Ref: 24010A-DE-EWC04
26th June 2025

**2-4 Burleigh Street & 20-24 Railway Parade, Burwood, NSW
Response to Submission comments**

The wind tunnel model study of the environmental wind conditions was completed in June 2024 with the wind tunnel model constructed to drawings supplied by NSW Housing Corporation Pty Ltd (PTI Architecture) and received 22nd May, 2024. The findings of the study were reported in MEL Consultants Report 24010-WT-ENV01, dated 17th December, 2024.

The Department of Planning, Housing and Infrastructure has issued a Request for Additional Information letter, dated 20th June 2025, requesting clarification of the following wind related queries in relation to the aforementioned MEL Consultants wind report :

DRAWING TITLE:
LEVEL 1 FLOOR PLAN- HOTEL
FACILITIES

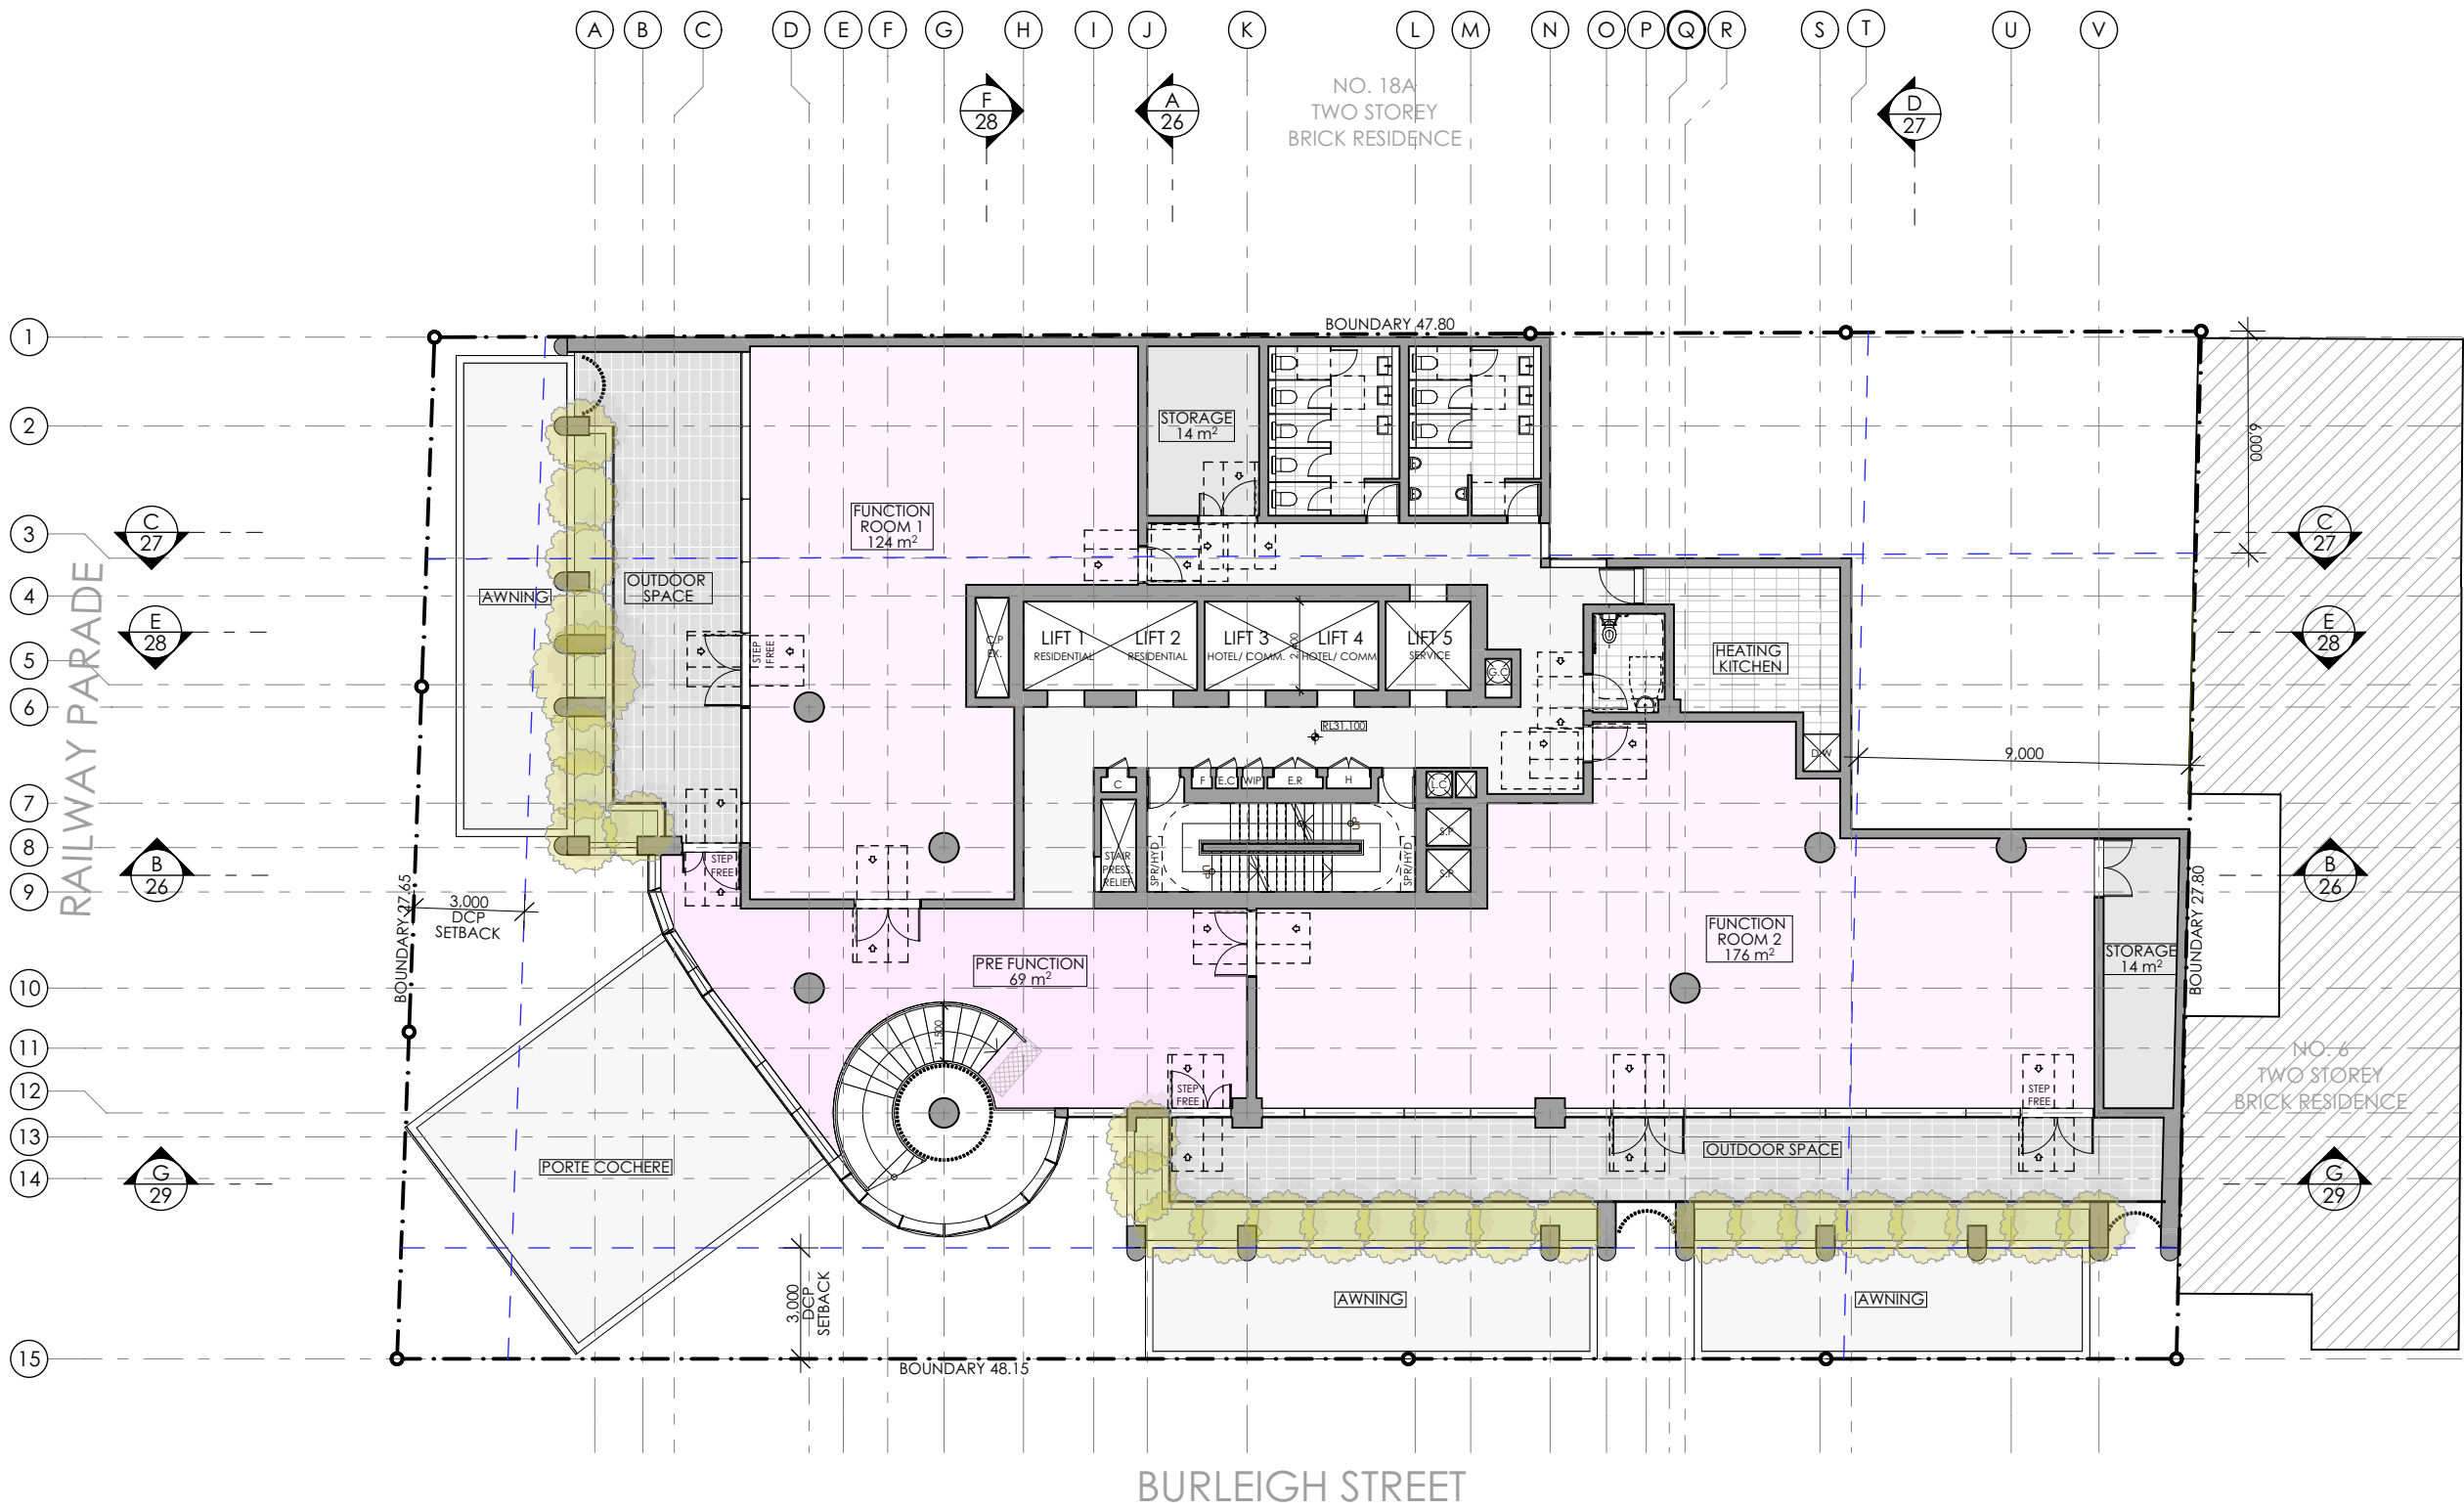
- a. *The Pedestrian Wind Environment Assessment (Appendix 25) (PWEA) indicates external residential COS areas and hotel/commercial external areas at levels 1, 2 and 36 meet standing comfort criteria levels. It is noted that most of these areas will include uses requiring people be seated. Provide further plans/details and mitigation measures, as needed, to demonstrate that the wind conditions in these areas will provide comfortable conditions for the intended use of the spaces.*

The wind conditions on Level 1 have been shown to meet the sitting comfort criterion.

DRAWING TITLE:
**LEVEL 2 FLOOR PLAN- HOTEL
FACILITIES**

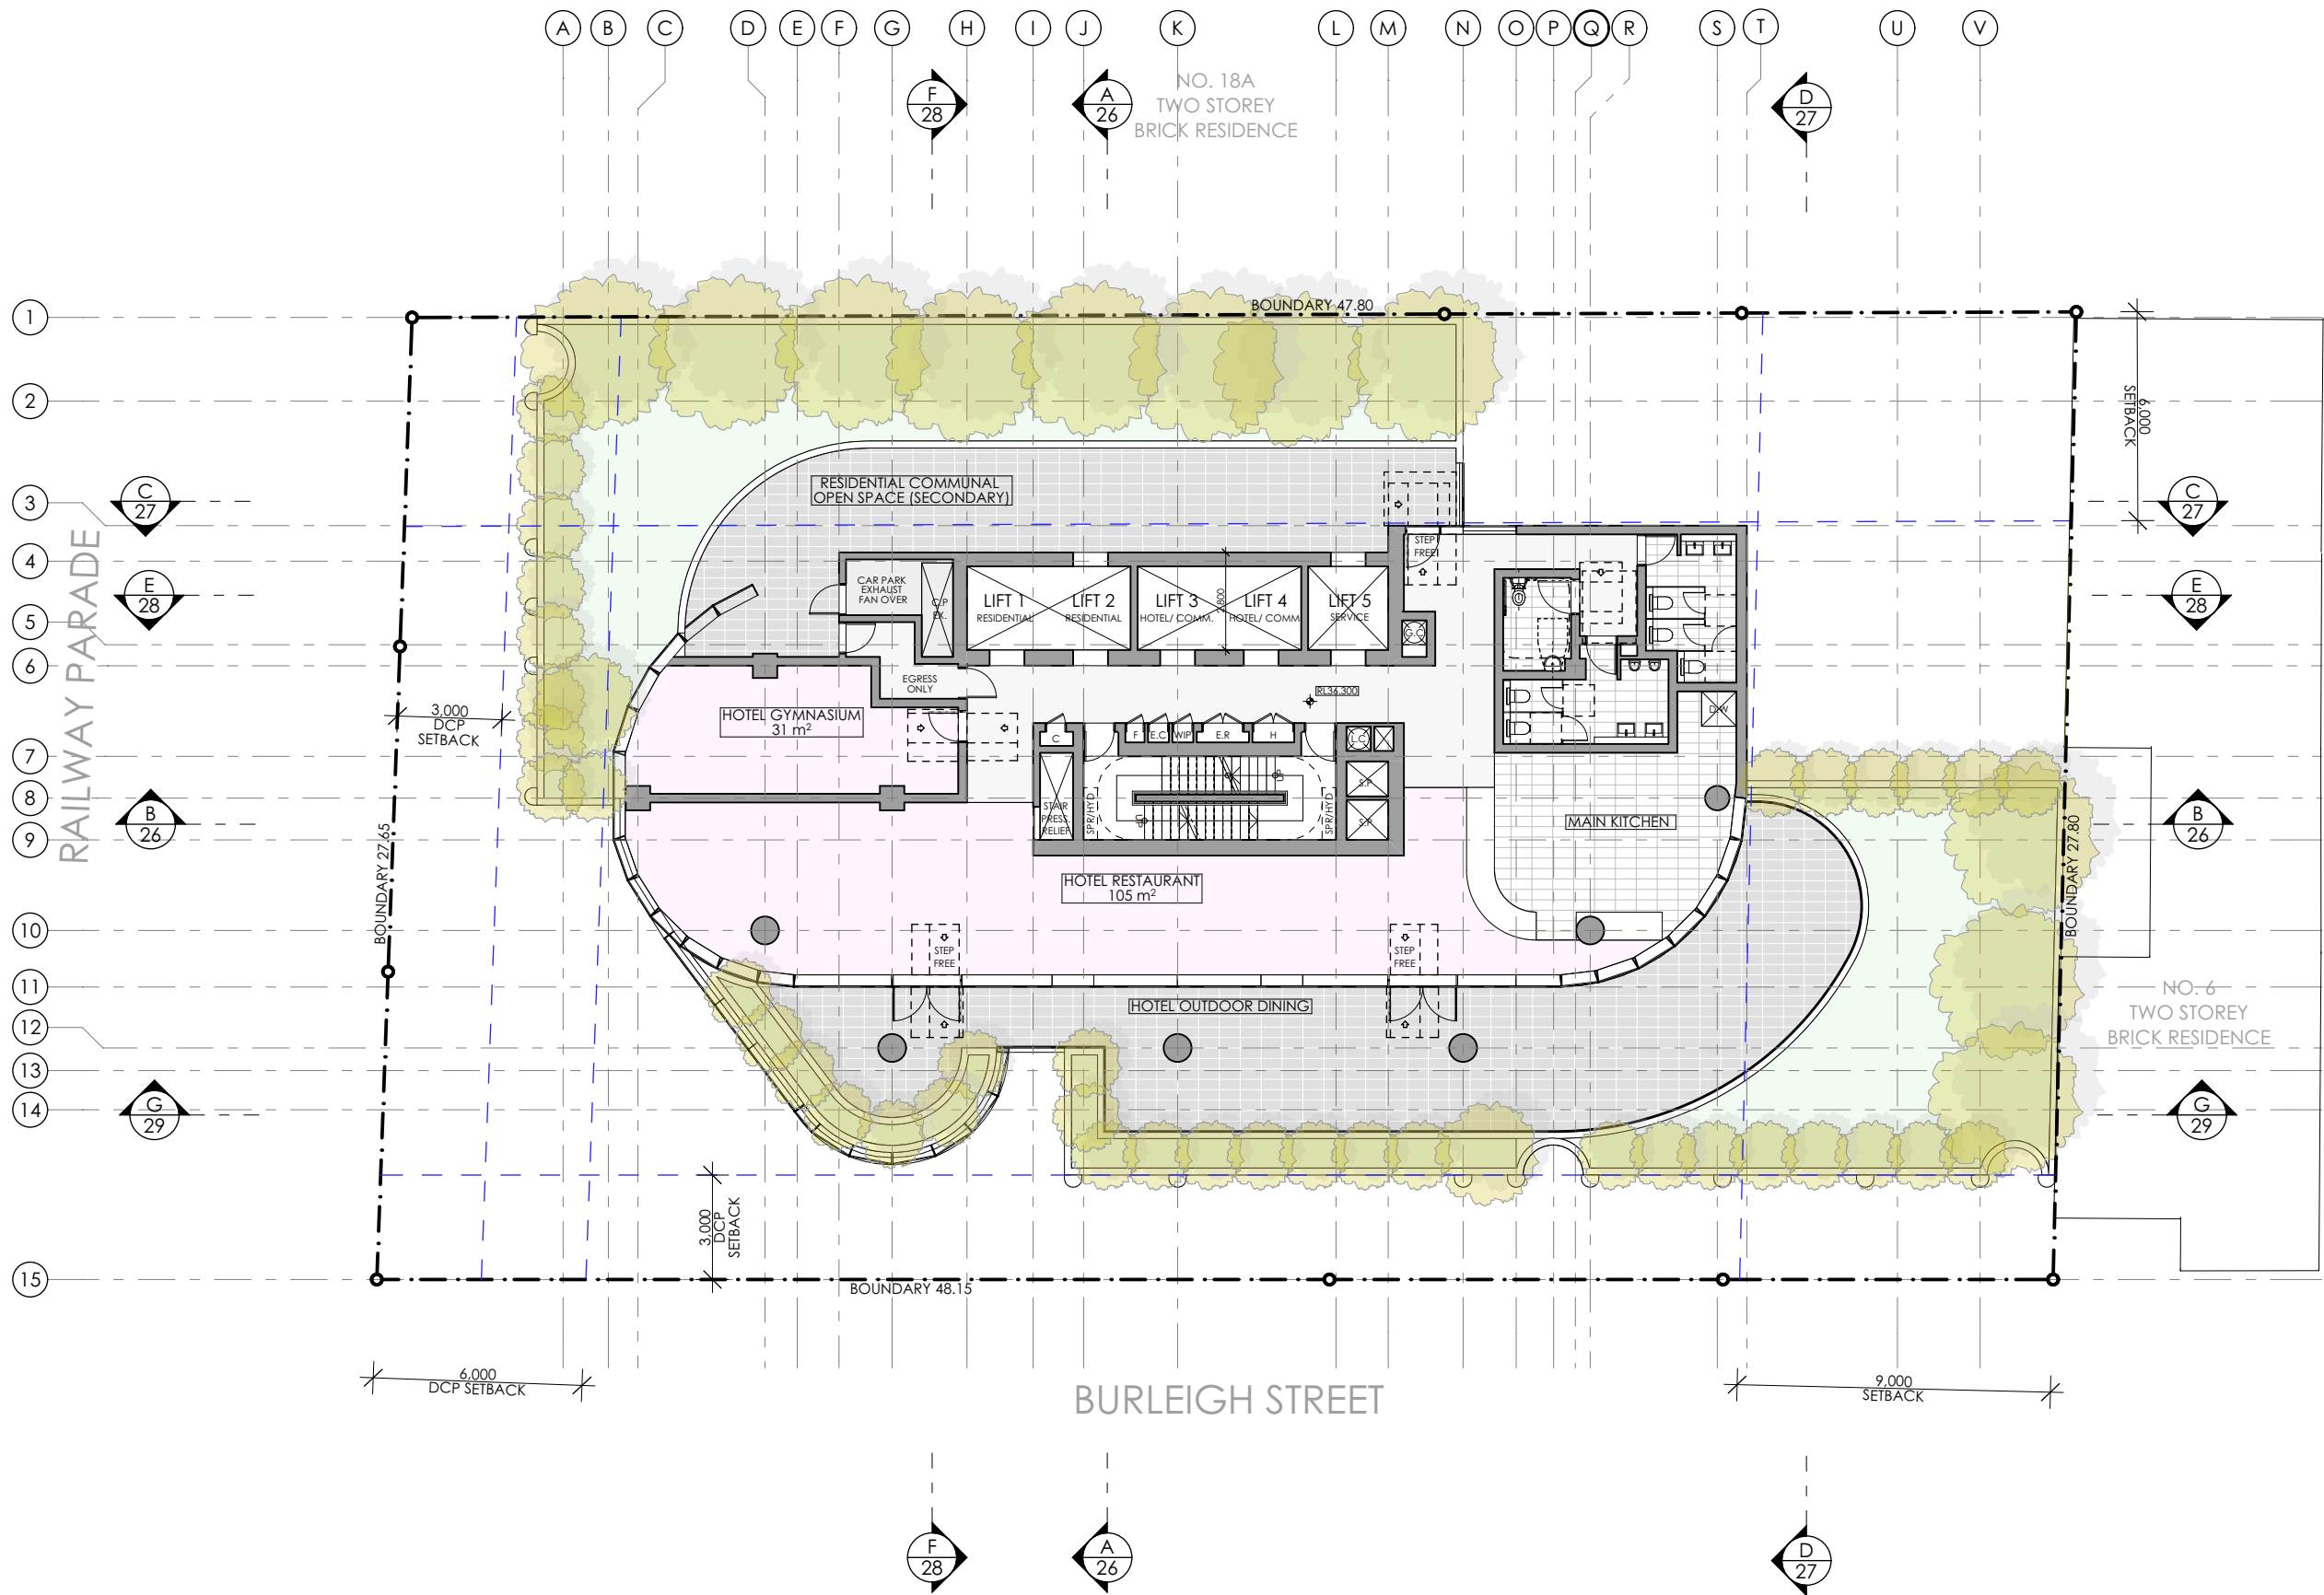
The wind conditions on Level 2 vary from achieving the sitting criterion (test location T7) to achieving the standing comfort criterion (test locations T5, T6, T8 & T9). To further improve the wind conditions on the Level 2 areas so that the sitting criterion is

achieved, it is recommended to increase the balustrade heights to 1.6m for the areas surrounding T5 & T6 and T8 & T9.
